CITY OF ALBUQUERQUE

November 30, 2021

Re: DEL TACO
1500 Gibson Blvd SE
Traffic Circulation Layout
Architect's Stamp 10-12-2021 (L15-D049)

AS-2.0

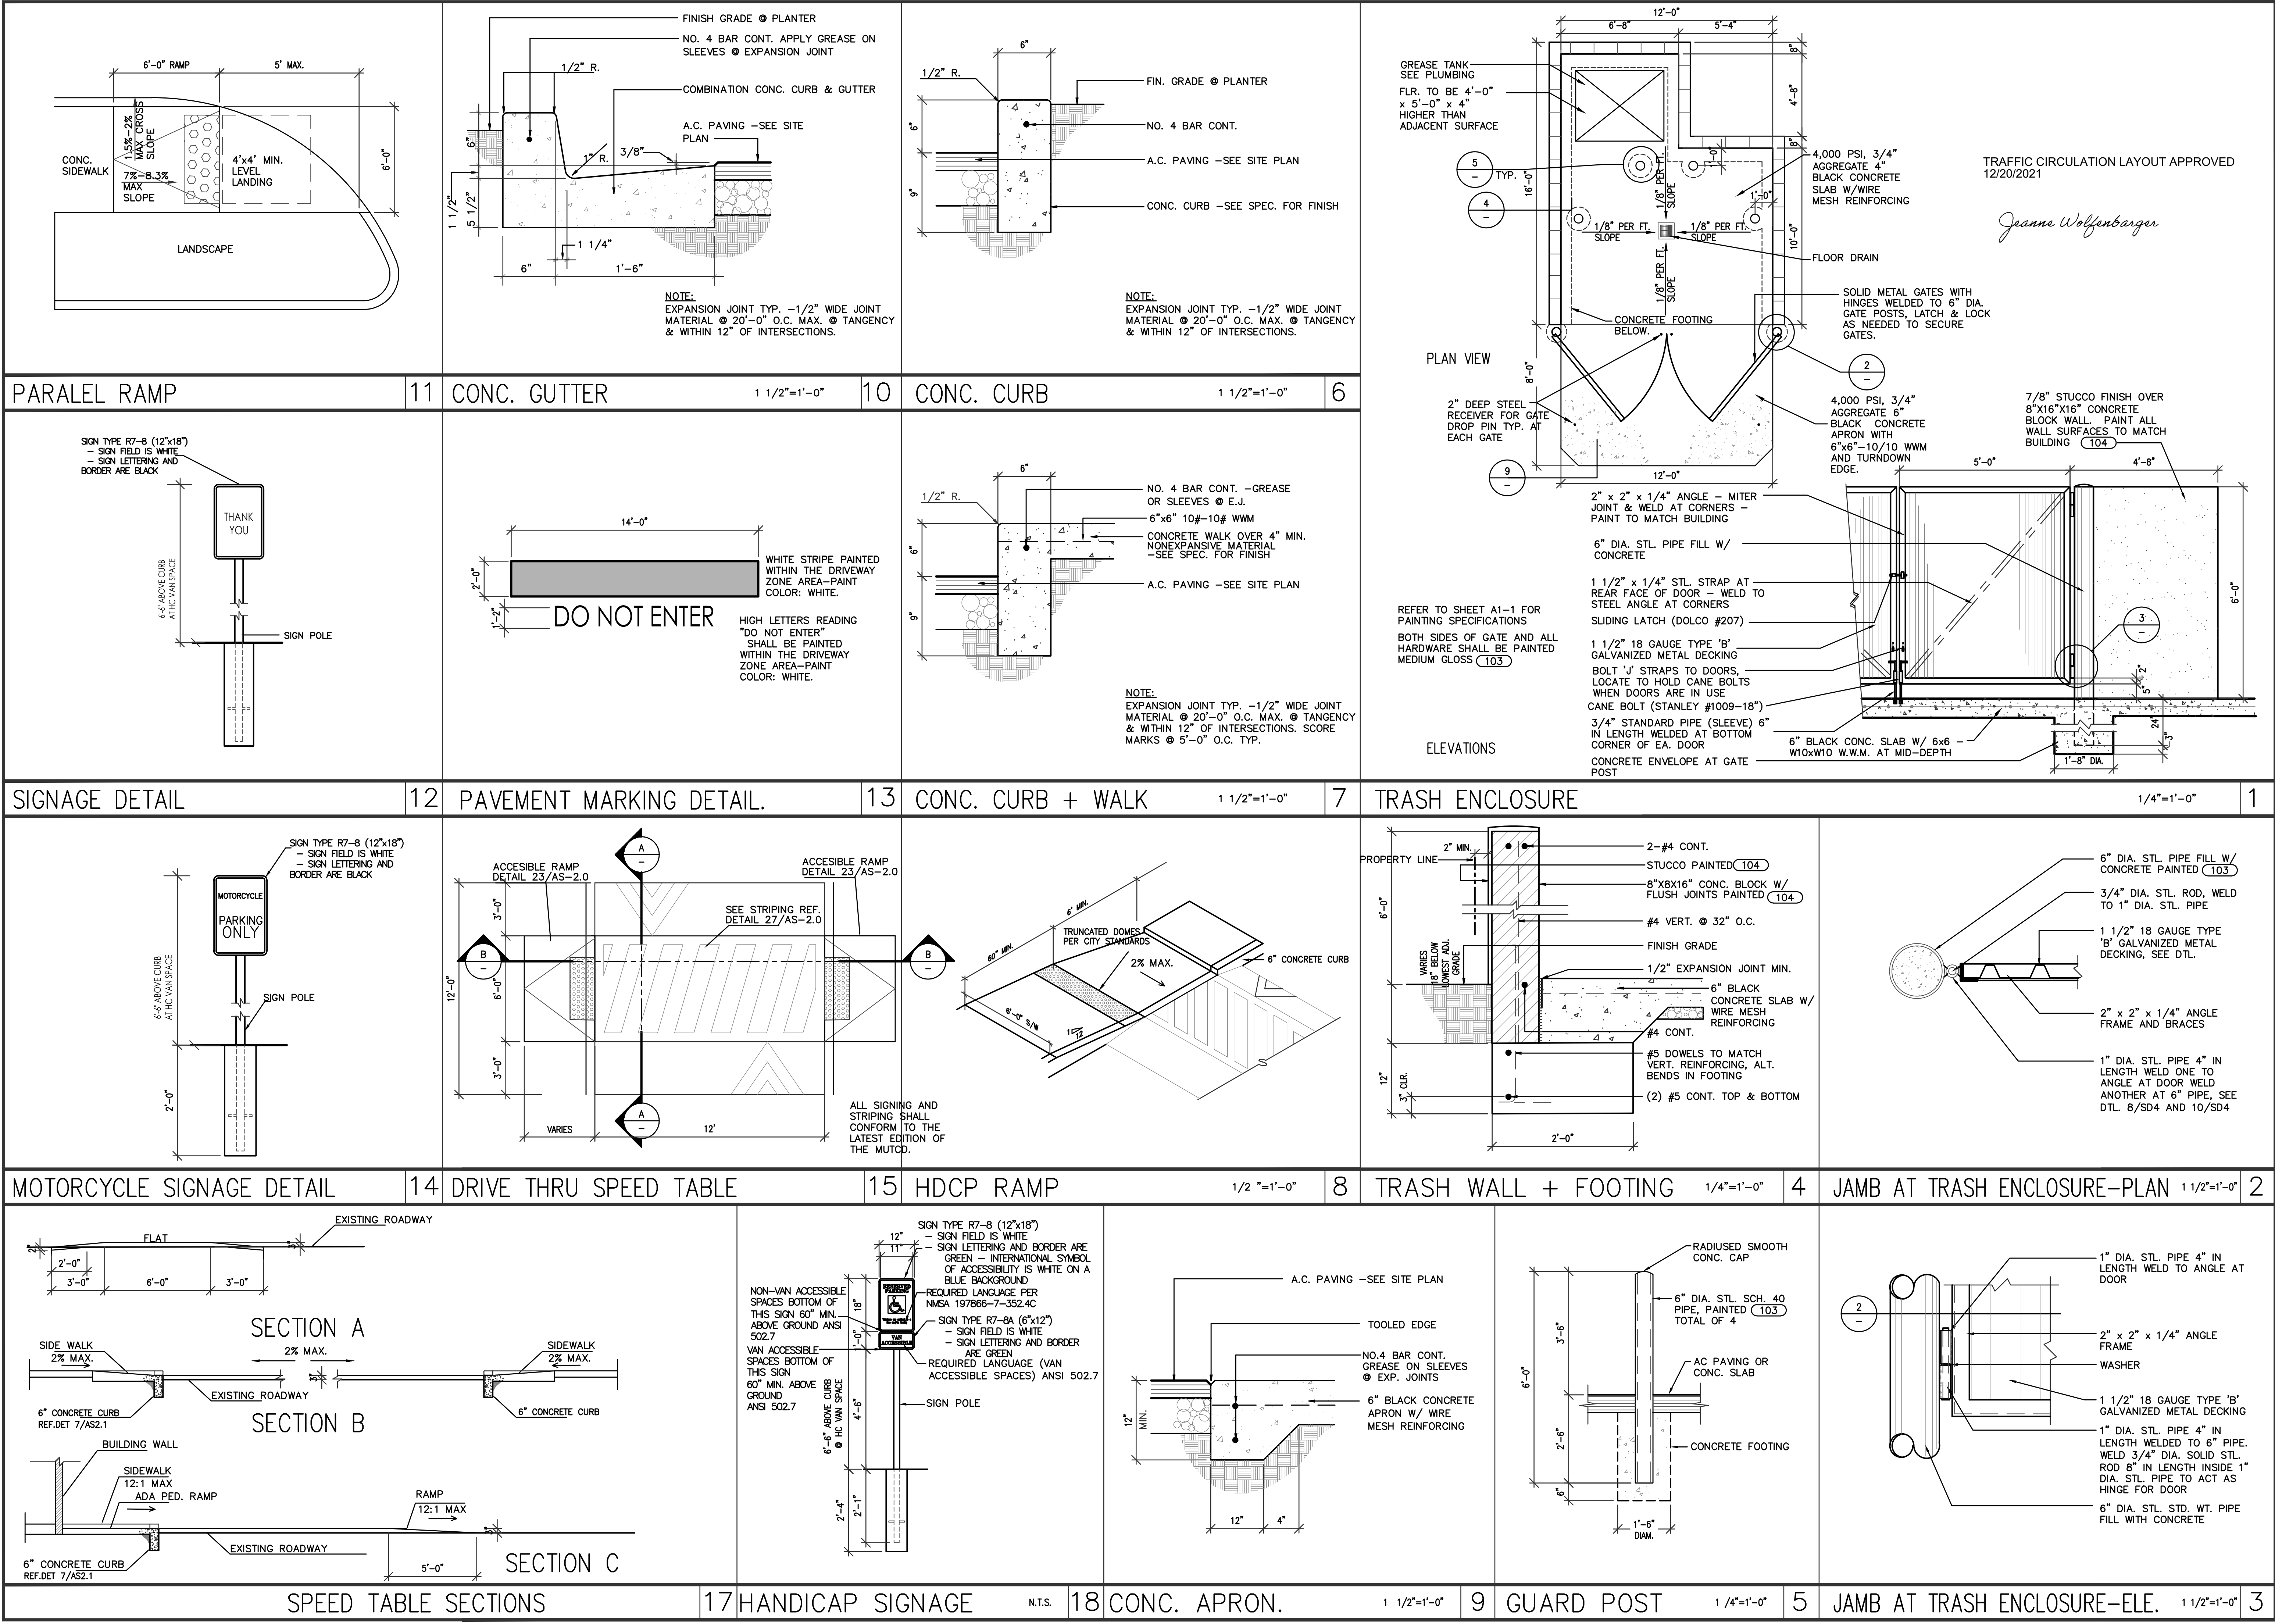
- Please provide/ design a speed table (for both 6' pedestrian path way) to address ADA accessibility and safety concern.
- Provide shared site access easement and/ or approved plat.
